DEVELOPMENT REVIEW BOARD
TRANSPORTATION DEVELOPMENT

DRB Project Number: 1006865
Carpenters Training Center

SUBJECT: Site Plan for Building Permit

Project Name: _____Urban Air Entertainment Center_____

1 Dumpster Floor Plan  
10\"/>

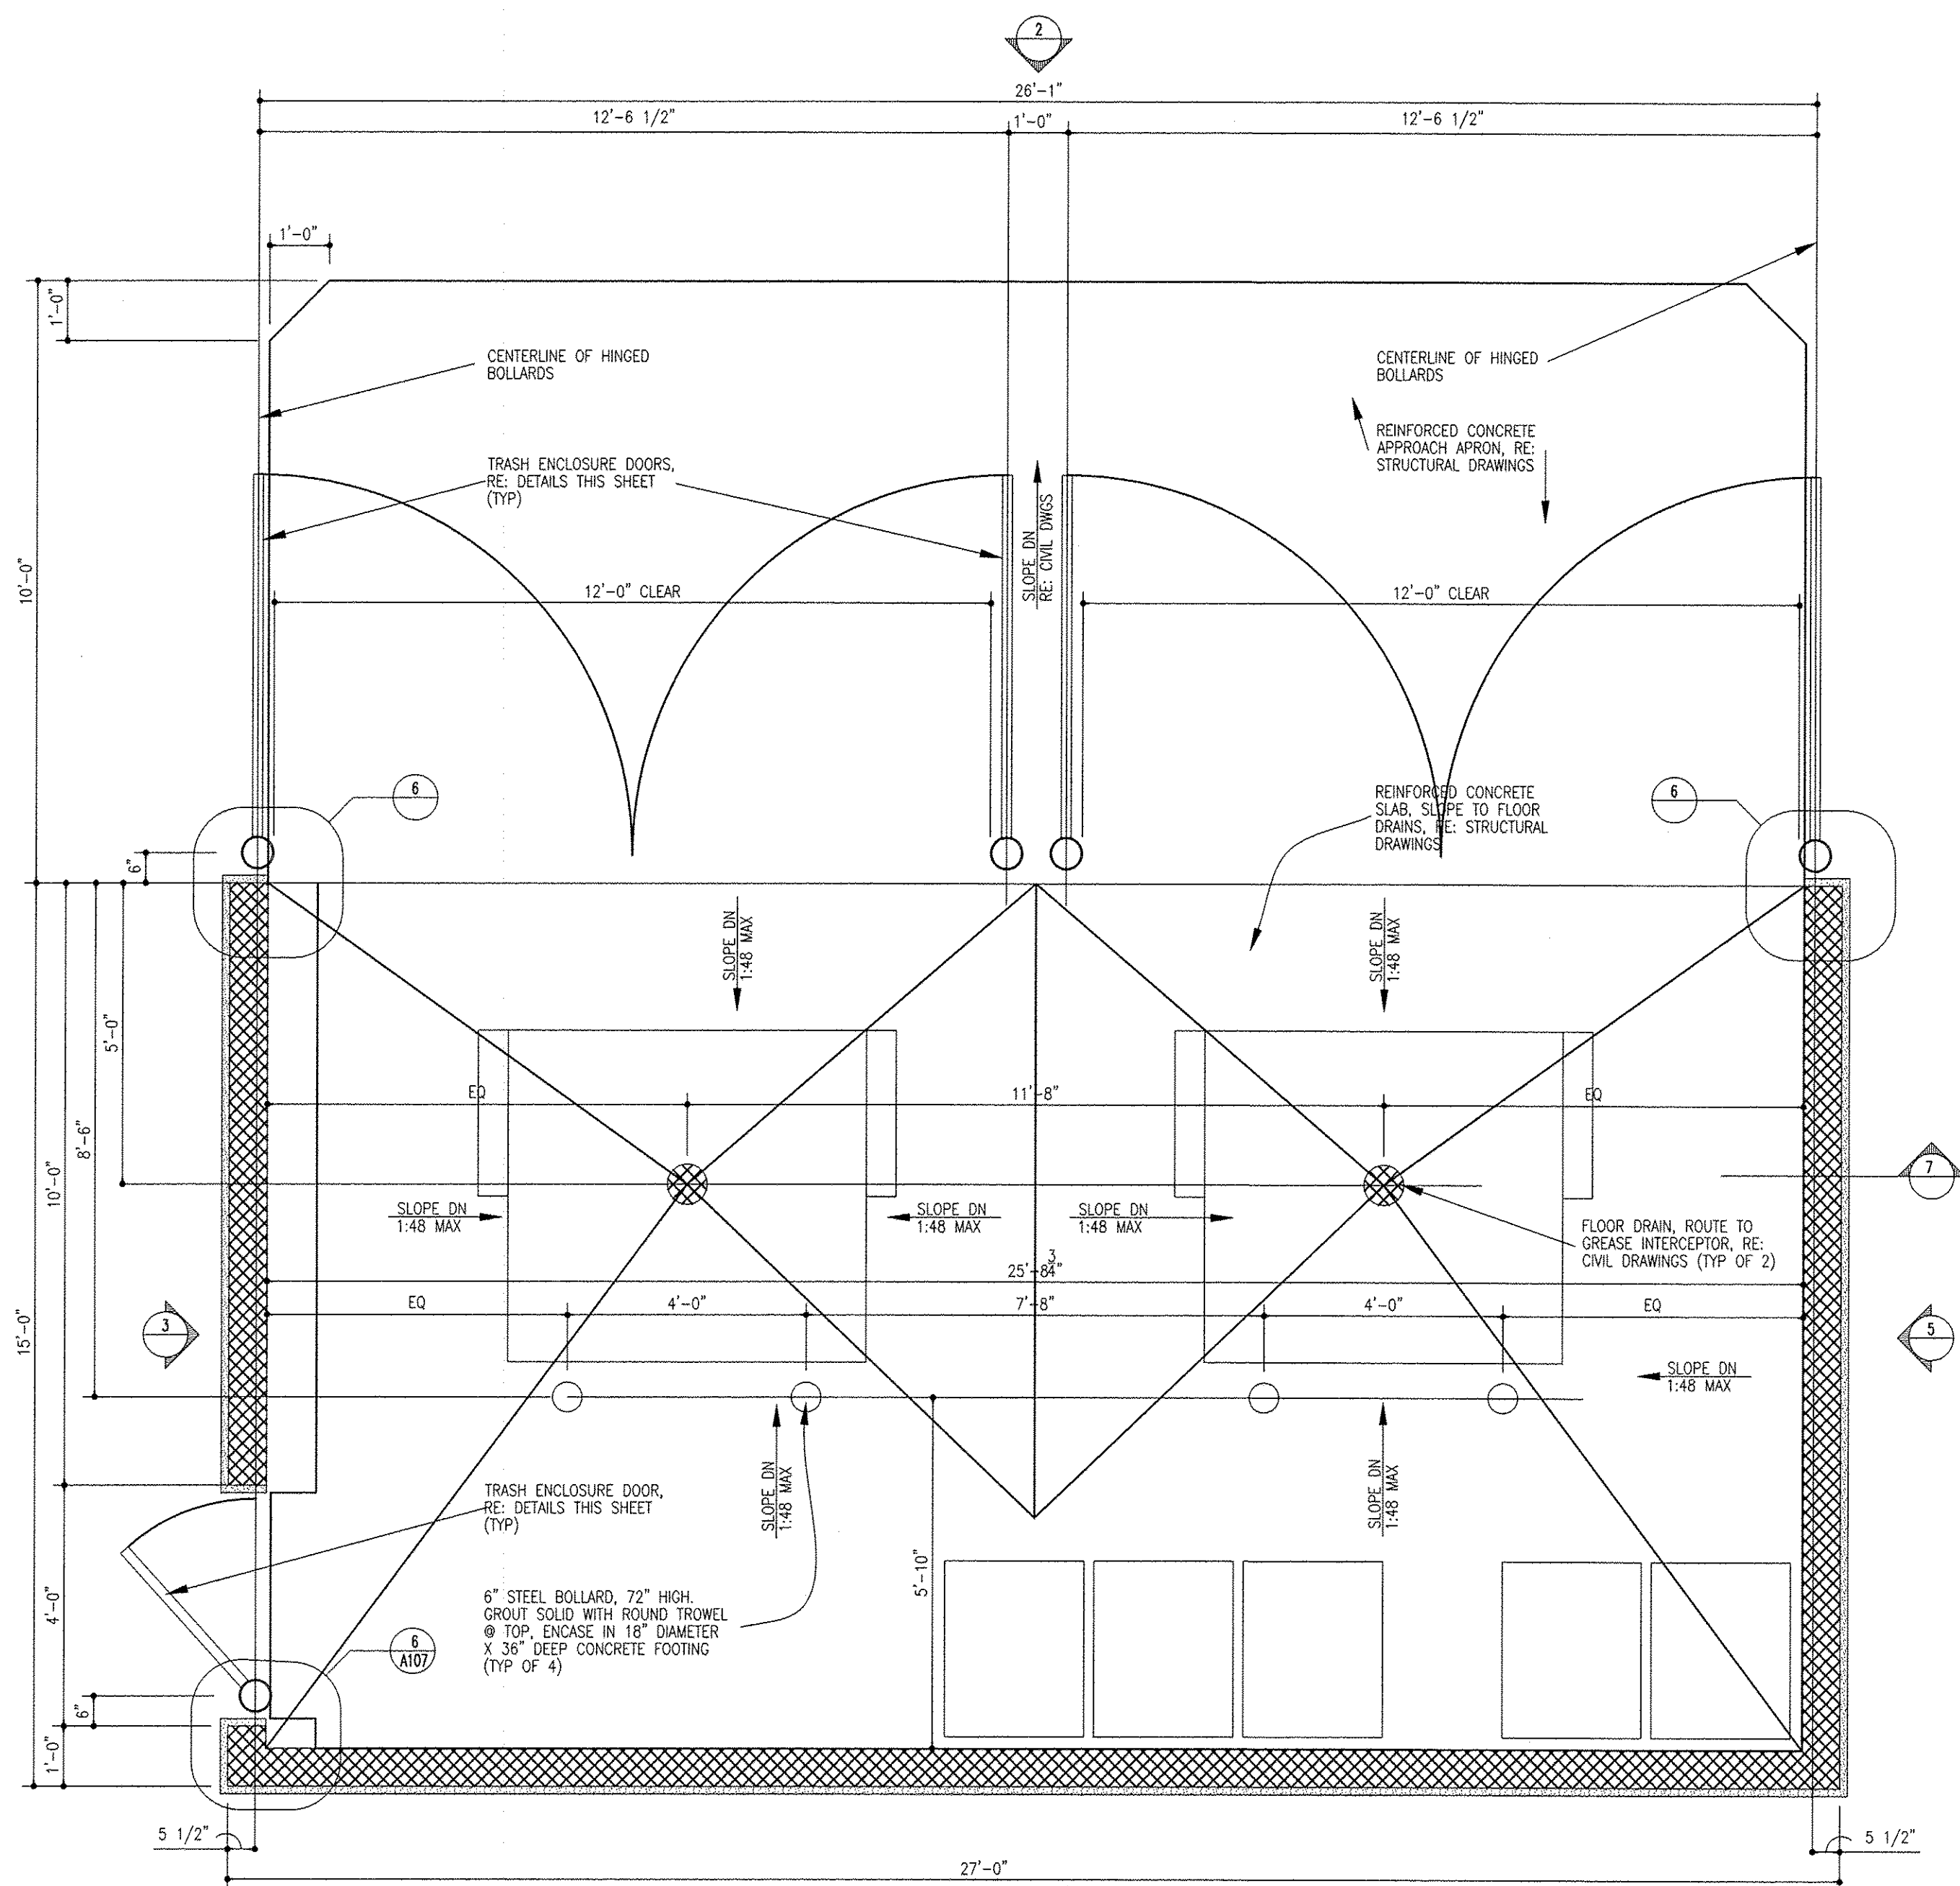
3. The refuse enclosure is to be "compatible with the architectural theme of the site" but neither the material nor color is called out on the detail.
4. Number 8 of the SPS state that area light shall be supplemented by pedestrian scale and or building mounted lighting. Did not see a detail or call out of either. Must be added.

idstudio<sup>4</sup> NORTH ELEVATION URBAN AIR

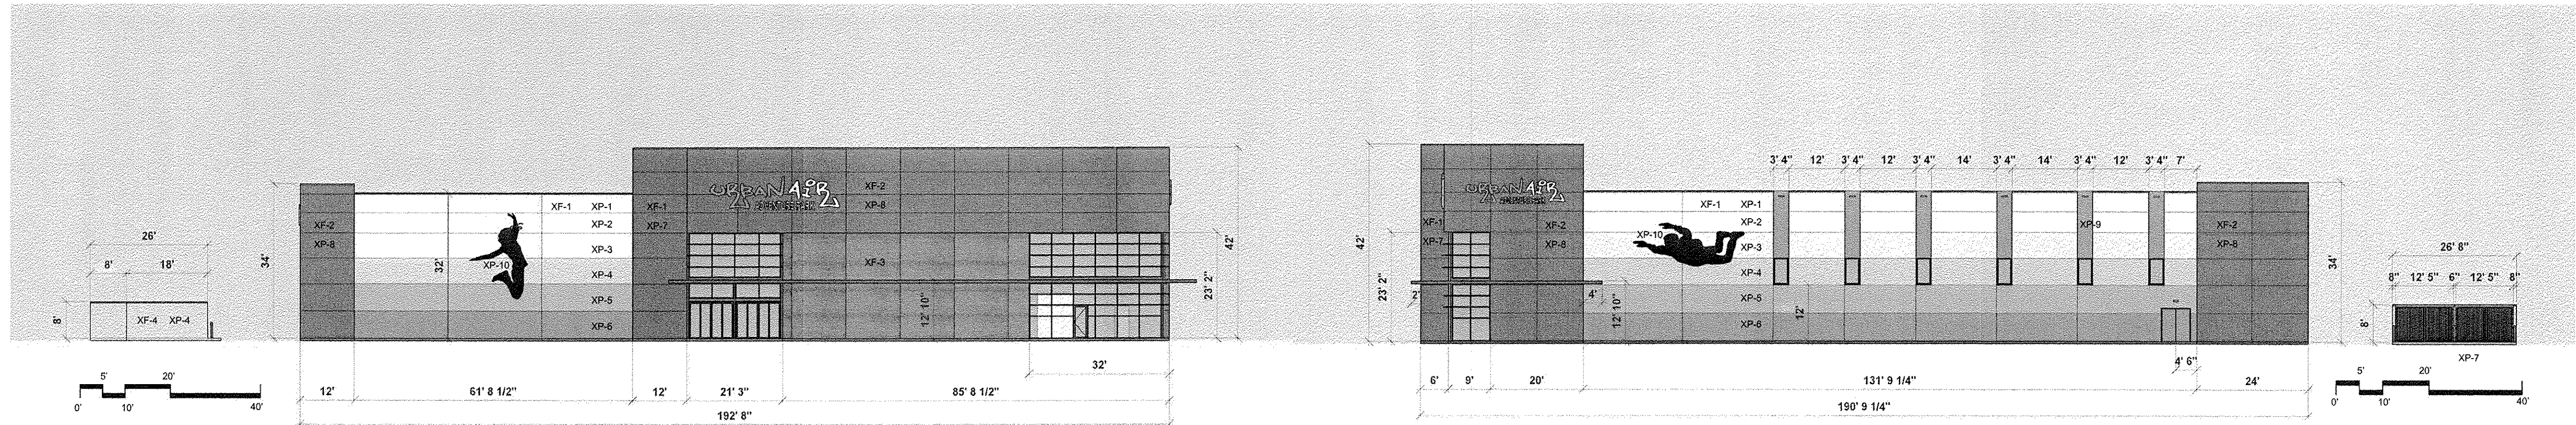
1. This plan must meet the requirements/regulations of the existing Site plan for Subdivision. One of the requirements is that the color, materials and architecture are compatible or achieve a continuity of design with the existing Carpenter Unions' building. How does the striation/bands of color match or compatible with the existing tan building?

2. The SPS states that accent colors for trim shall match or be compatible with the existing building. How is the orange color, which makes up more than 50% of the north elevations and close to 50% of the west elevations, achieves a continuity of design with the Union building? The majority of the building is tan stucco with some minor rust trim and blue/green glass windows?

6. Signage is to provide consistency in appearance and quality and compliment the visual character of the site. The figures on the building are considered signs. How do these provide consistency when there is nothing else like it on the site (development)?

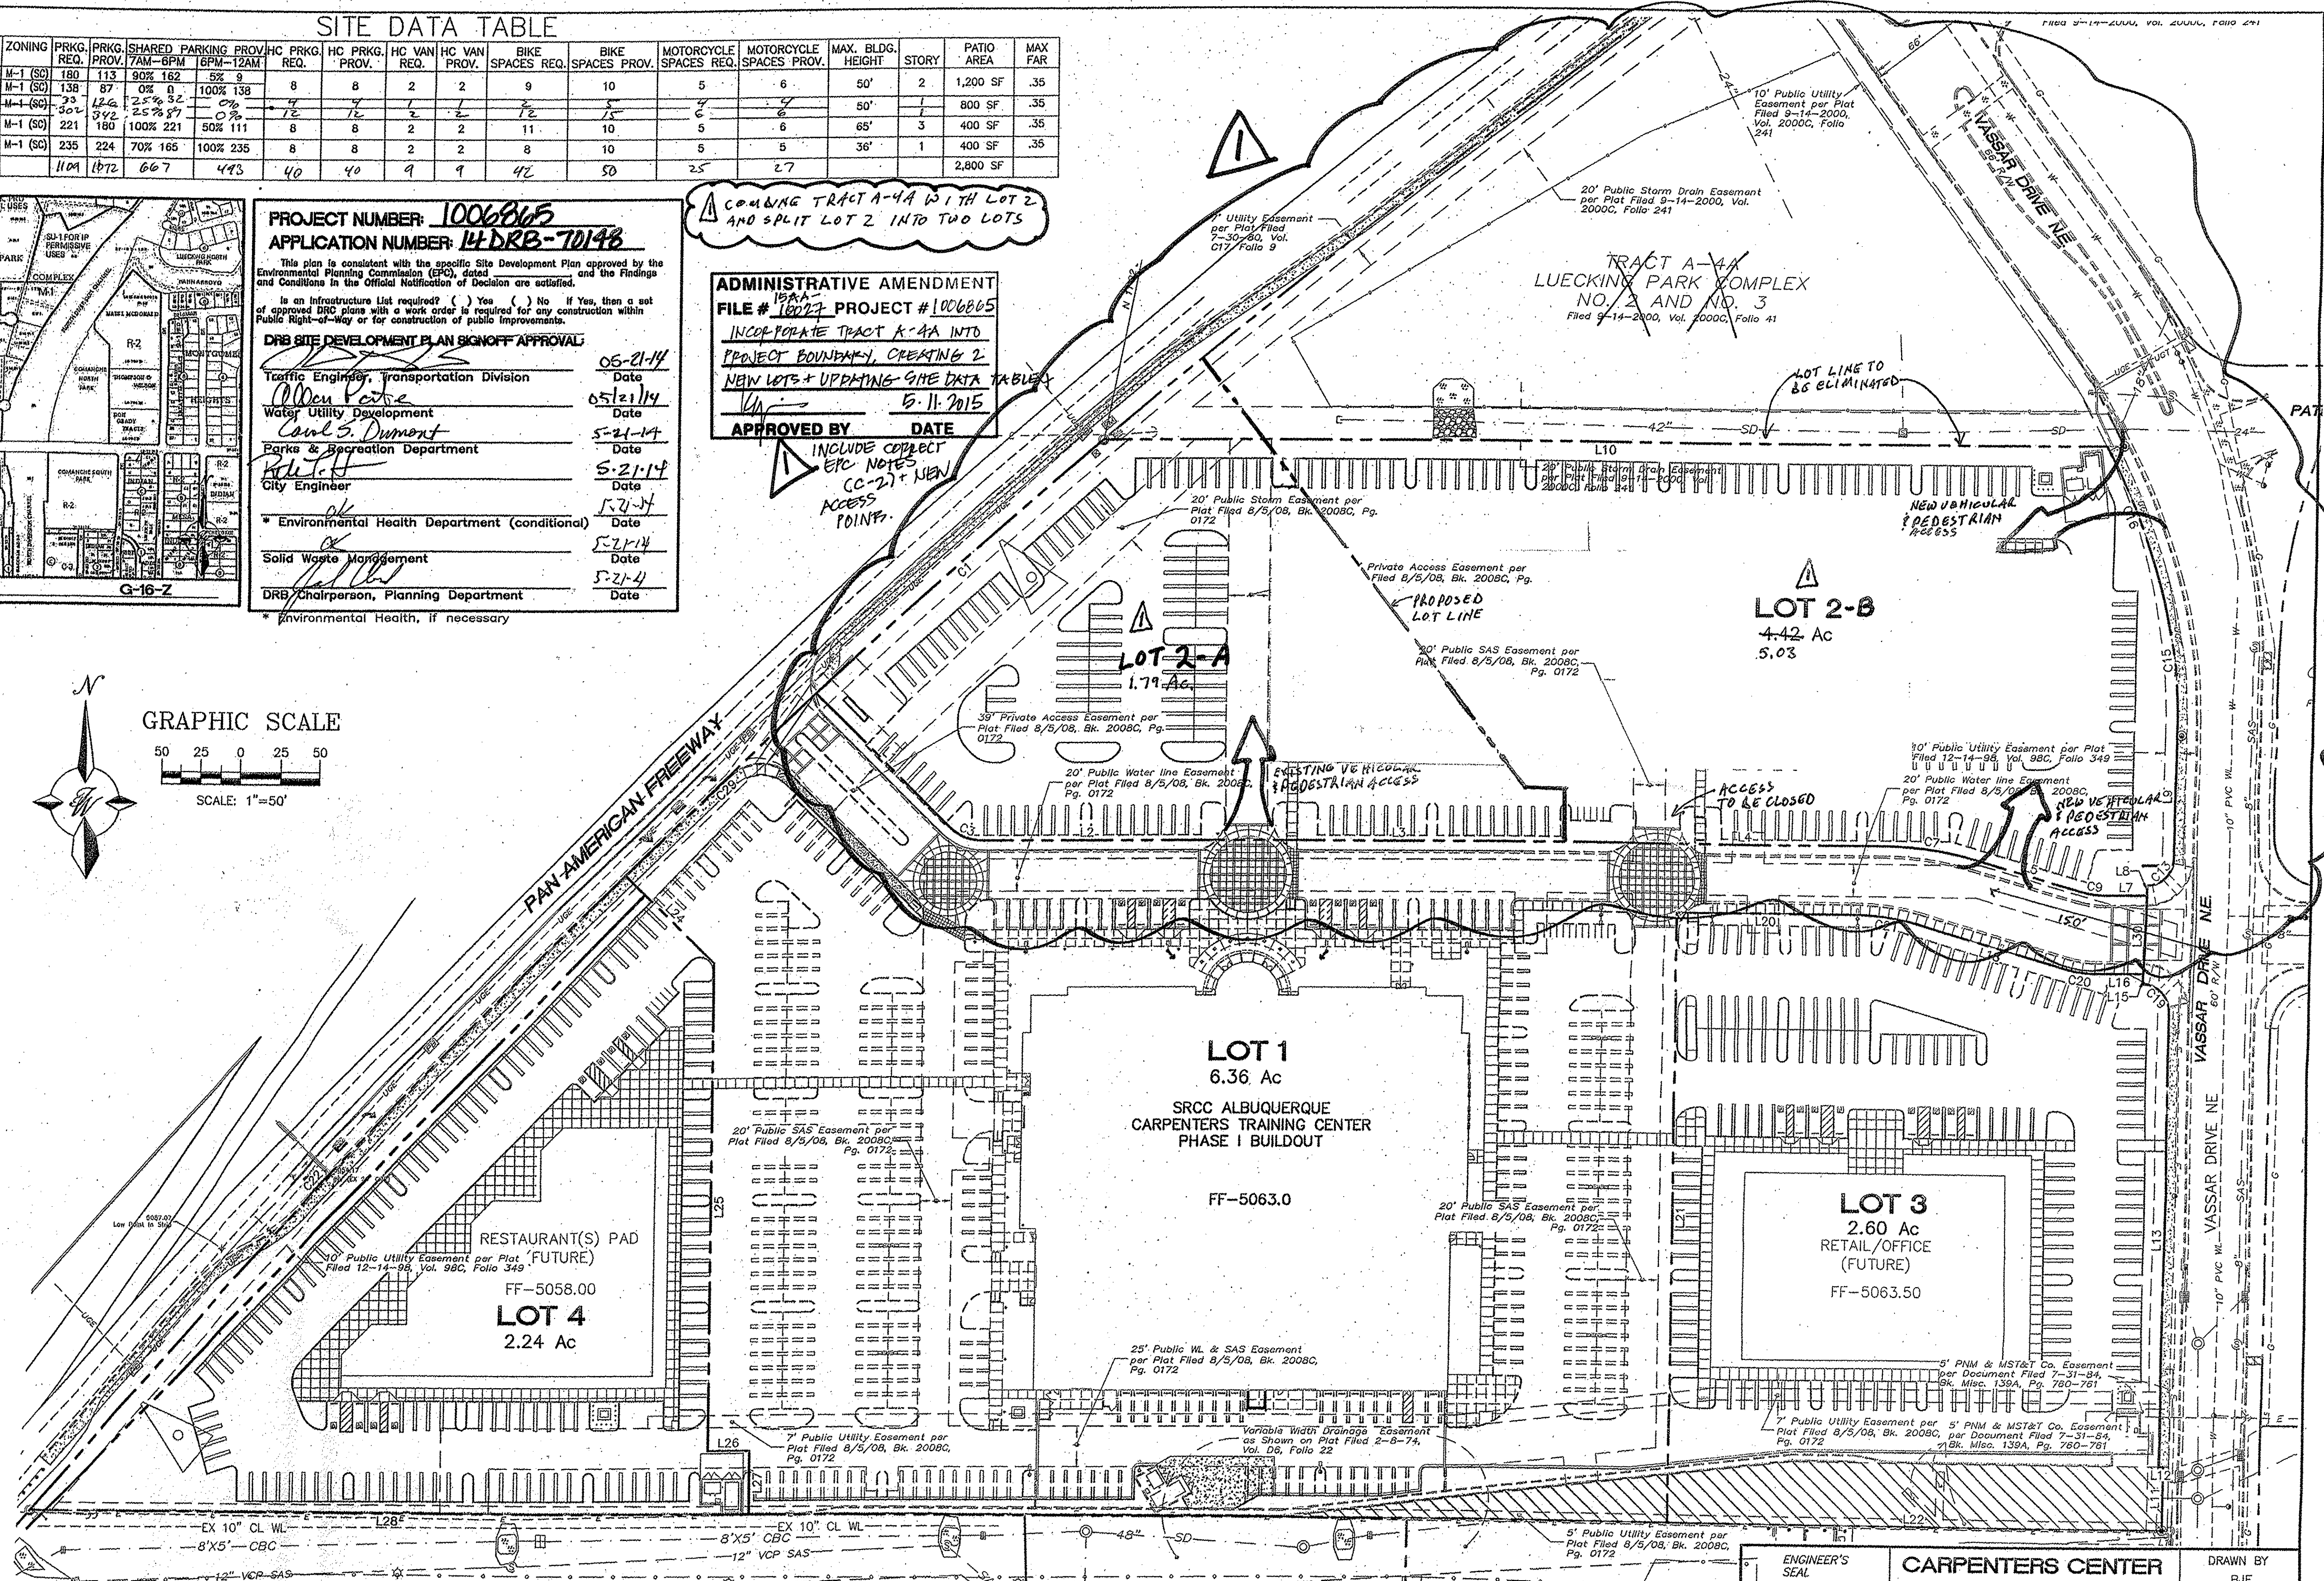
1. Please list the width and length for all existing and proposed parking spaces. Some dimensions are not shown.
2. The handicap accessible spaces must be a minimum of 8.5 ft. in width.
3. The handicap accessible spaces must include an access aisle. Van accessible aisles should be 8ft wide; all others should be 5ft wide.
4. The ADA access aisles shall have the words **"NO PARKING"** in capital letters, each of which shall be at least one foot high and at least two inches wide, placed at the rear of the parking space so as to be close to where an adjacent vehicle's rear tire would be placed. (66-1-4.1.B NMSA 1978)
5. Motorcycle parking spaces shall be designated by its own conspicuously posted upright sign, either free-standing or wall mounted per the zoning code.
6. Please add a note on the plan stating "All improvements located in the Right of Way must be included on the work order."

7. A difference in paving material, color or pattern must be provided for crosswalks and pedestirna links between parking areas and building must be clearly visible and highlighted with enhanced paving. The site plan calls out the location of crosswalks but does not provide a detail.

8. Patio areas are required with 25% covered. Patios areas in sf are called out but no detail of the actual area (outlined on the plan) and how much is covered. It states (#12) that this can be down with trees with grates or umbrellas.

9. There are landscaped islands and tree grates that are not shown on any of the other plans except the landscaped plan. Need to be shown on the other sheets including the actual site plan. One landscaped area removes a parking space. Need to verify parking count.
